Ribble Valley Borough Council
Housing & Development Control

Application no: **3/2021/1212**

Address: **Higher Newfield Edge Burnley Road Gisburn BB7 4JN**

The Local Highway Authority have viewed the plans and highway related documents and have the following comments to make:

DRAWING NAME
LOCATION PLAN

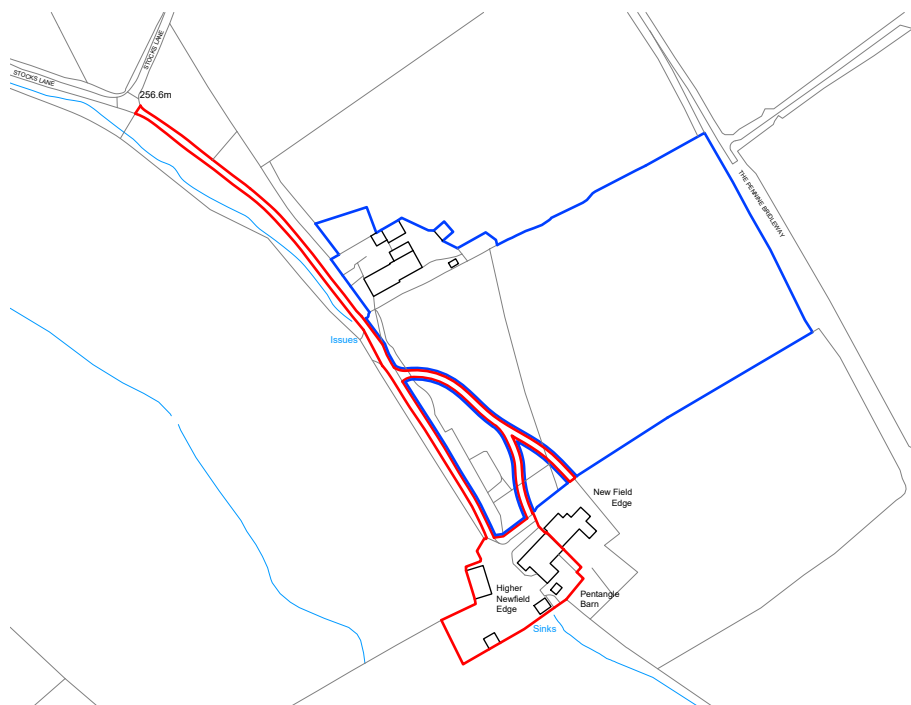
However, the Applicant owns, as shown on ZMA drawing number 01 titled "Location Plan," all the land within the vicinity of the site, up until the driveway to New Field Edge.
